Hunter Indoor Sports Centre – Technical Review

11th November 2024

The Hunter Indoor Sports Centre went on public exhibition on the 15th October 2024 as a State Significant Development (SSDA) as application number SSD-65595459.

DRAWING TITLE
**CIVIL ENGINEERING PACKAGE
CONCEPT ACCESS PLAN**

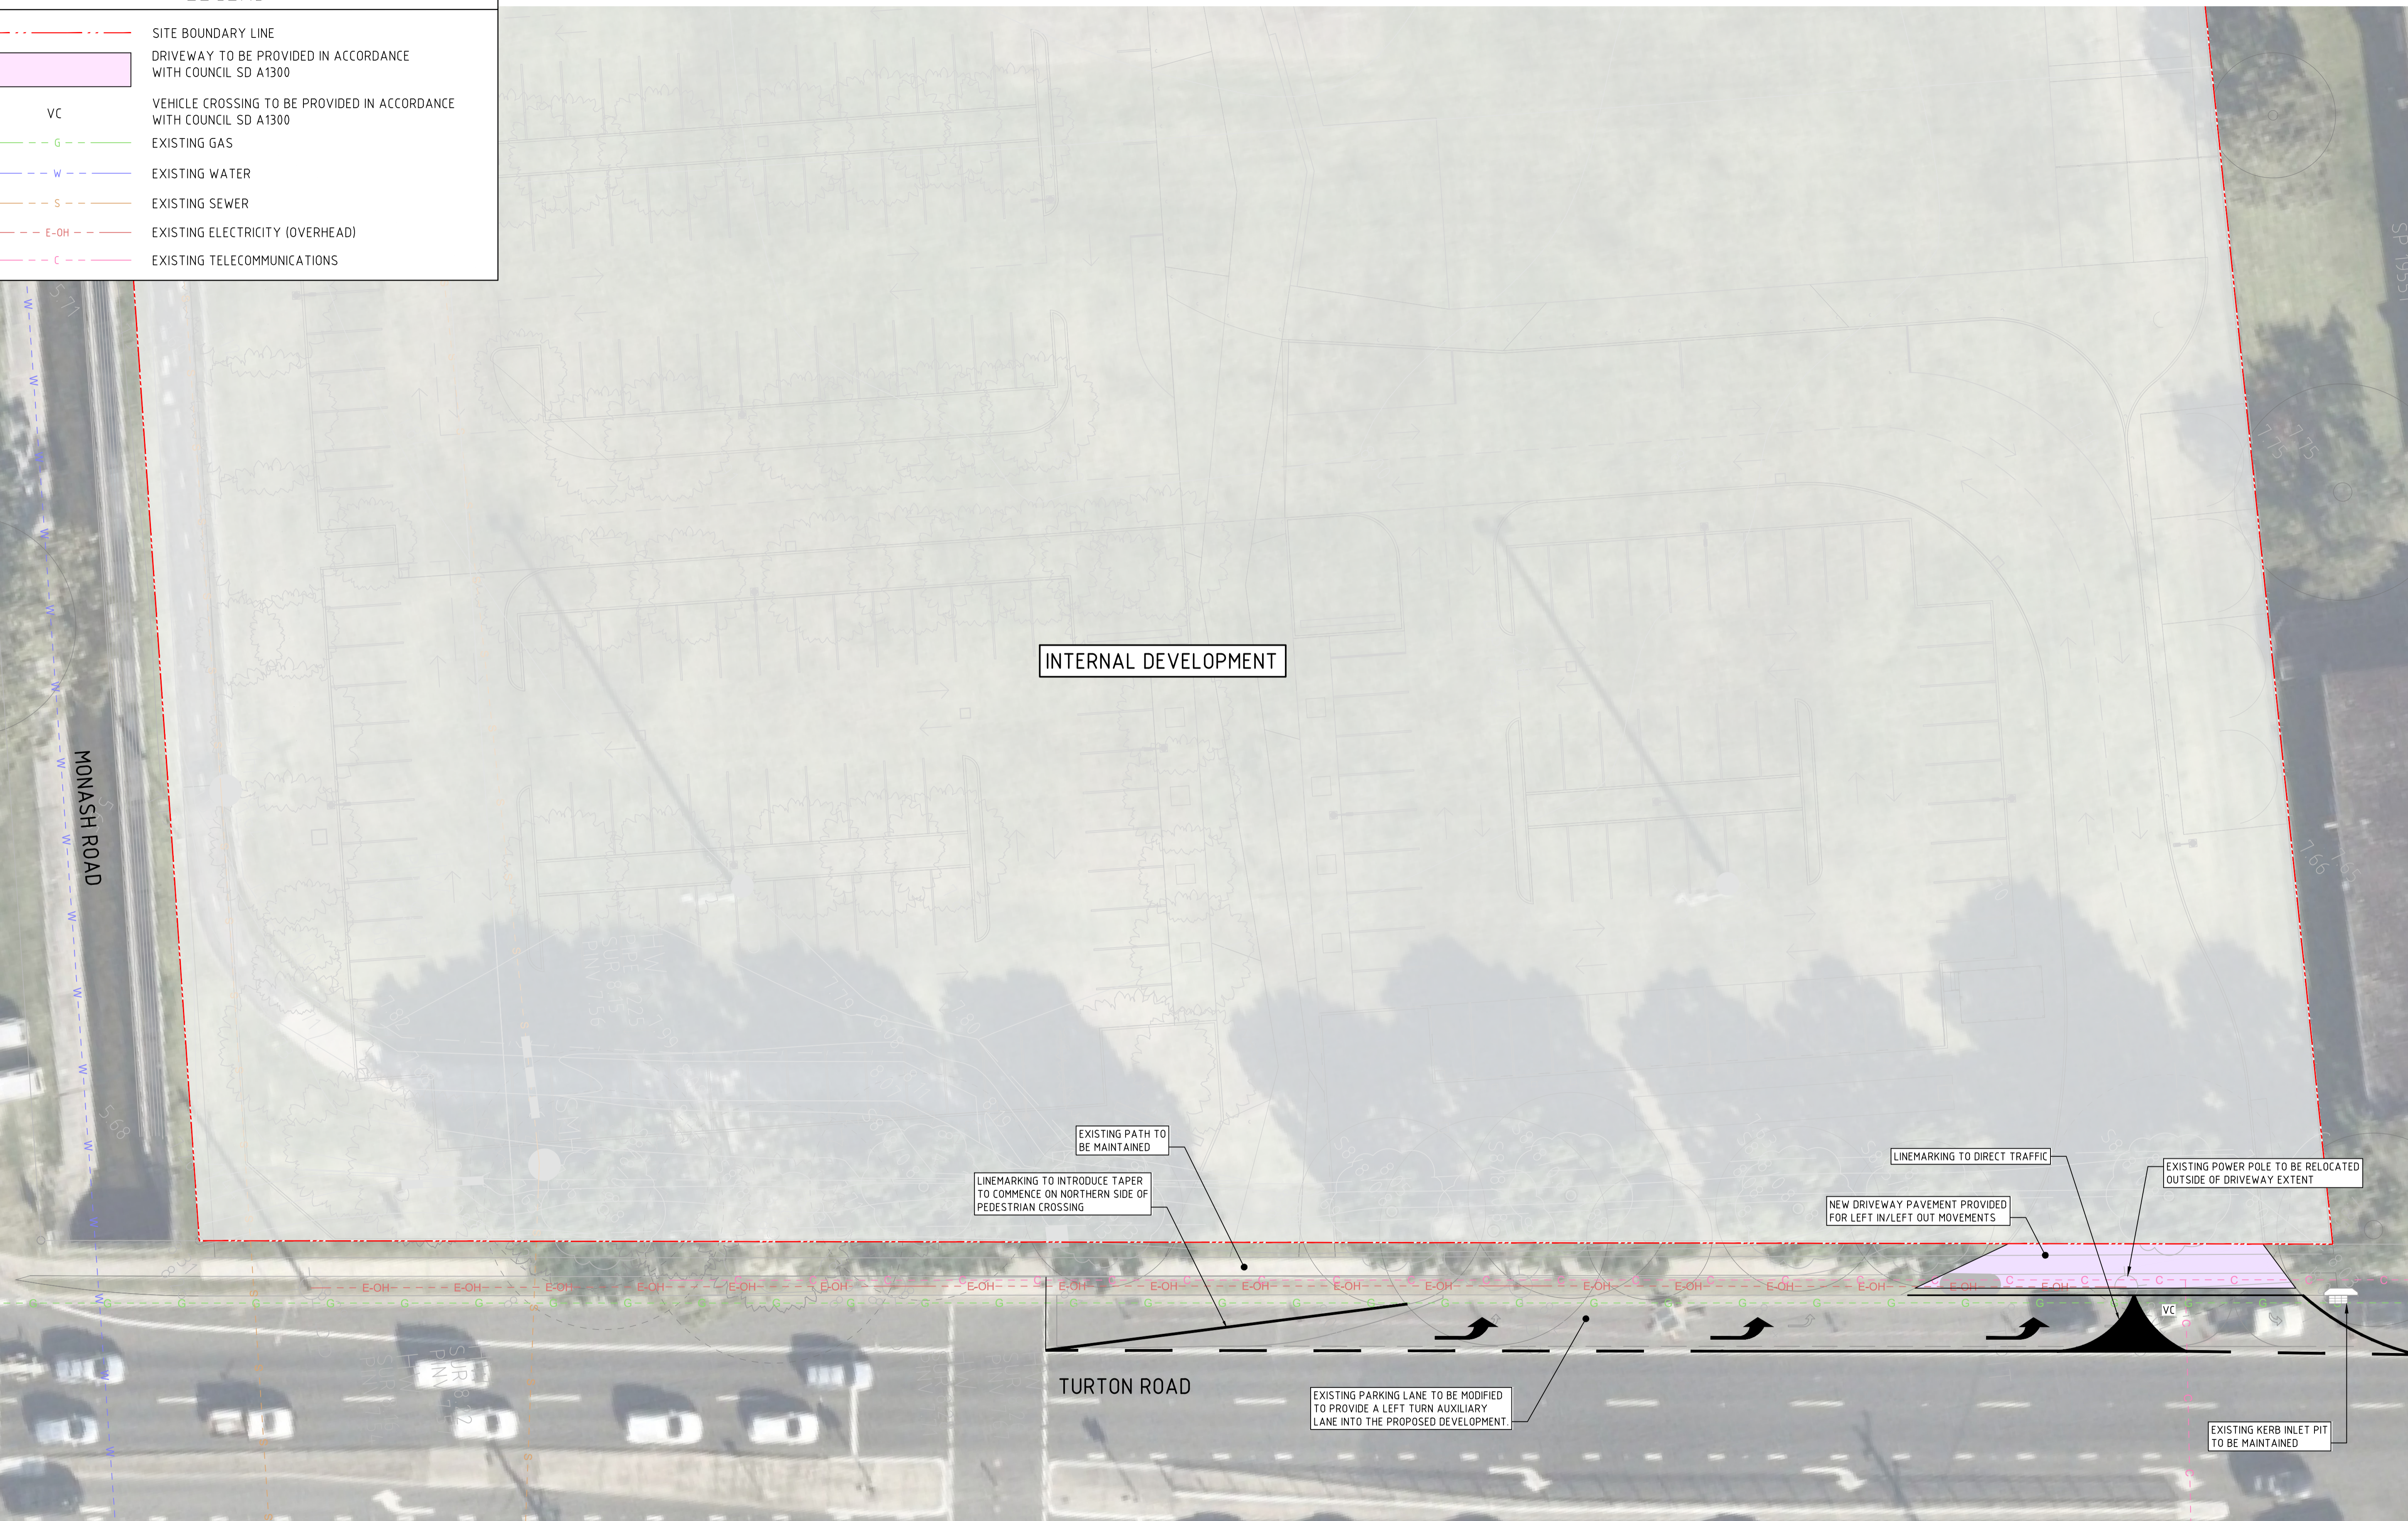
Item 1: Driveways shown within the civil plans have the potential to impact existing MJS traffic operations and shuttle bus pick-up/drop-off.

Recommendation: Civil plans be assessed against current shuttle bus and MJS TMP operations to ensure no impact to existing operations.
